Application No: FP/220/20/PL
Site Address: Kenwood Court 6 The Midway Felpham PO22 7EZ
Description of works: Car port and rearrangement of existing parking spaces.

Thank you for your internet representation made on 29th January 2021 which has been recorded as an objection with the comments as follows:

PROPOSED CAR PORT
PLANS AND ELEVATIONS

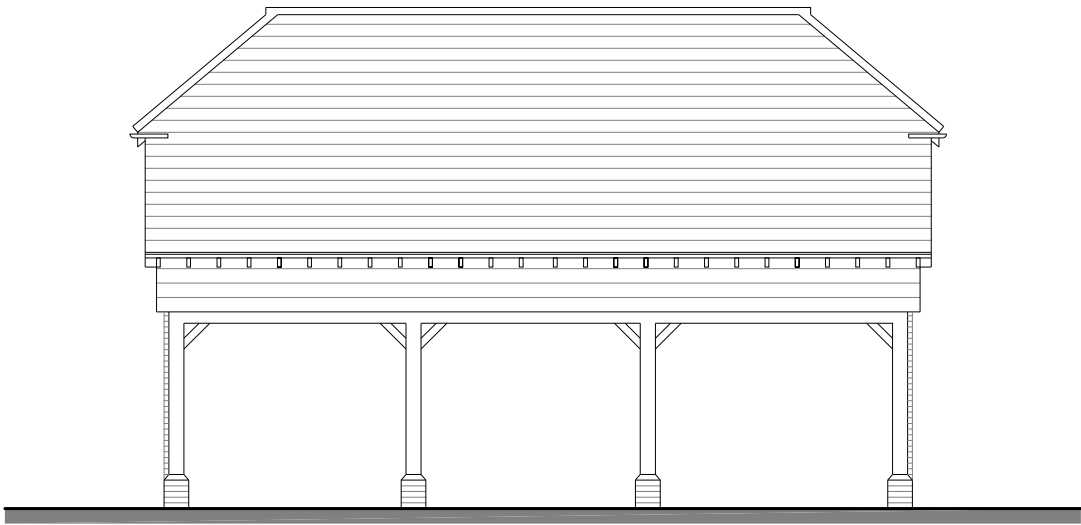
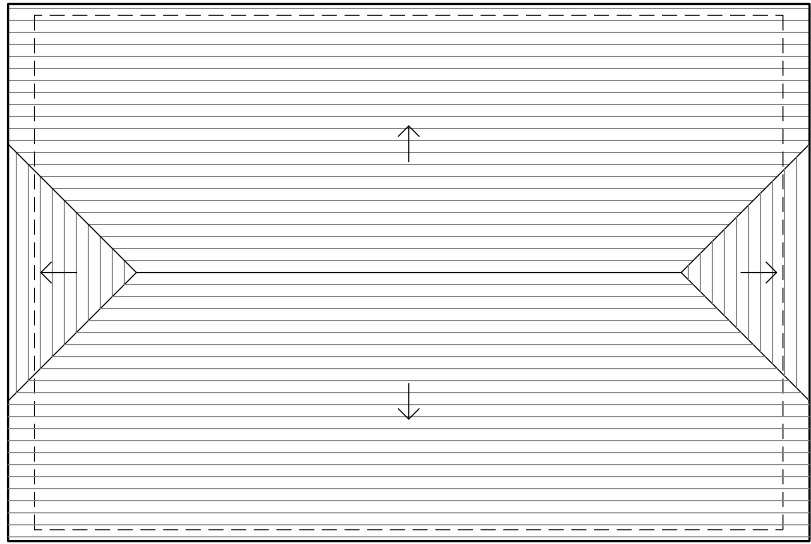
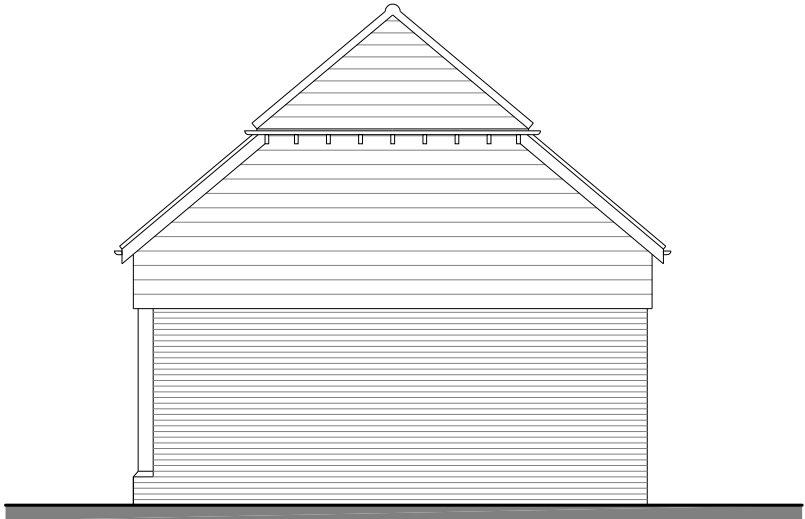
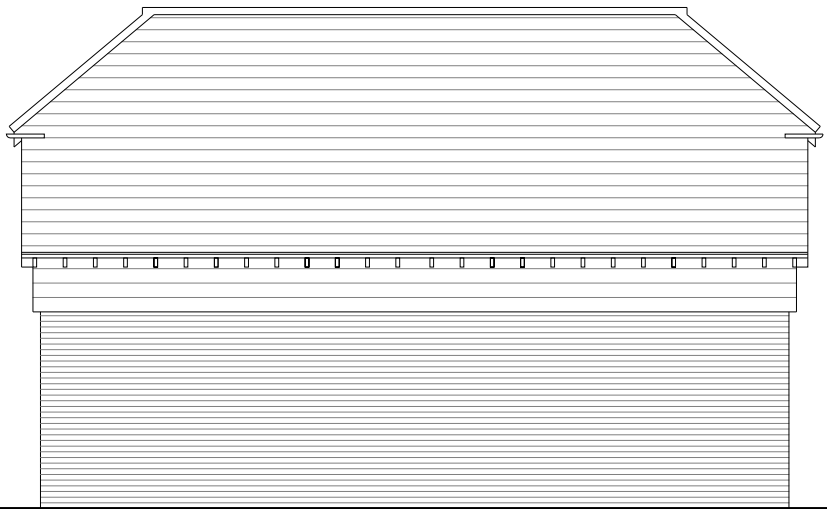
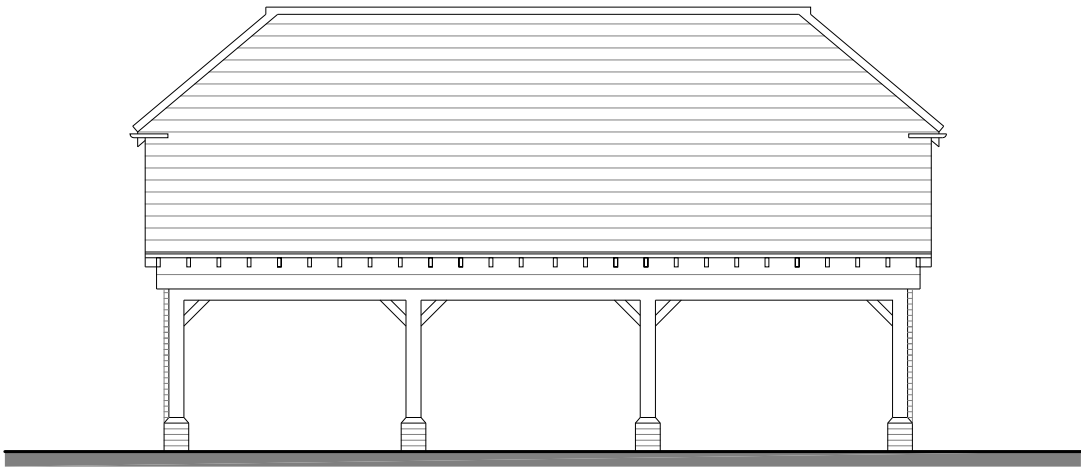
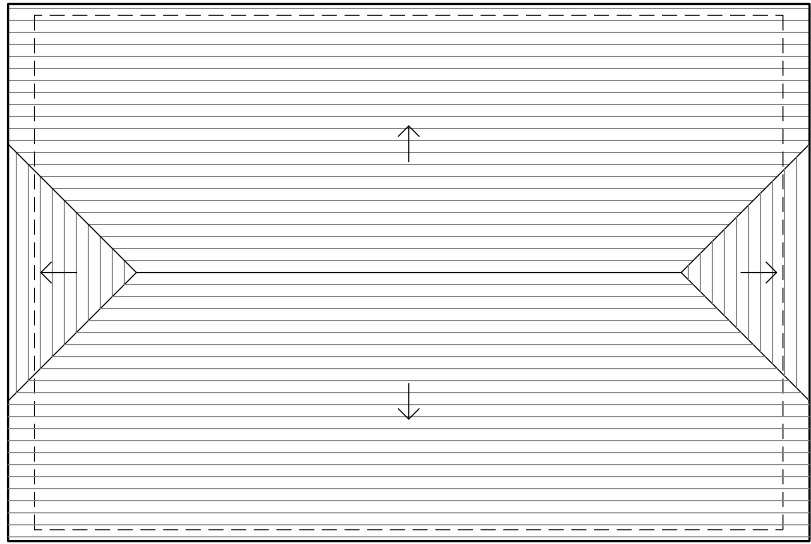
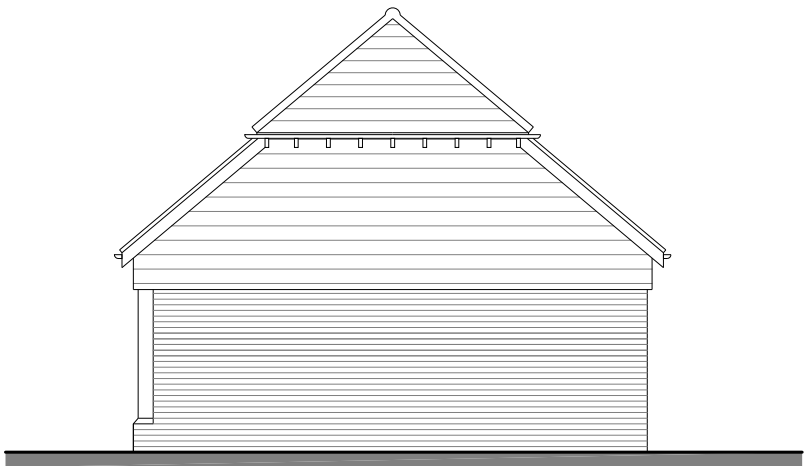
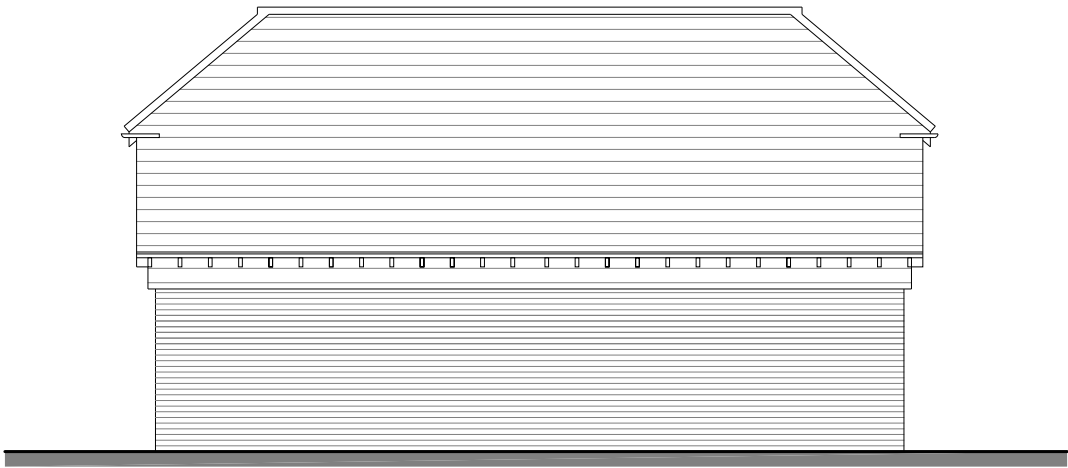
Having looked at the proposed plans I am concerned that the size of the structure (approx 6m high) is too high for the space - this would in my opinion be too high a structure for a mere 'car port' the roof height needs to be reduced to a more neighbourly height (4m?).
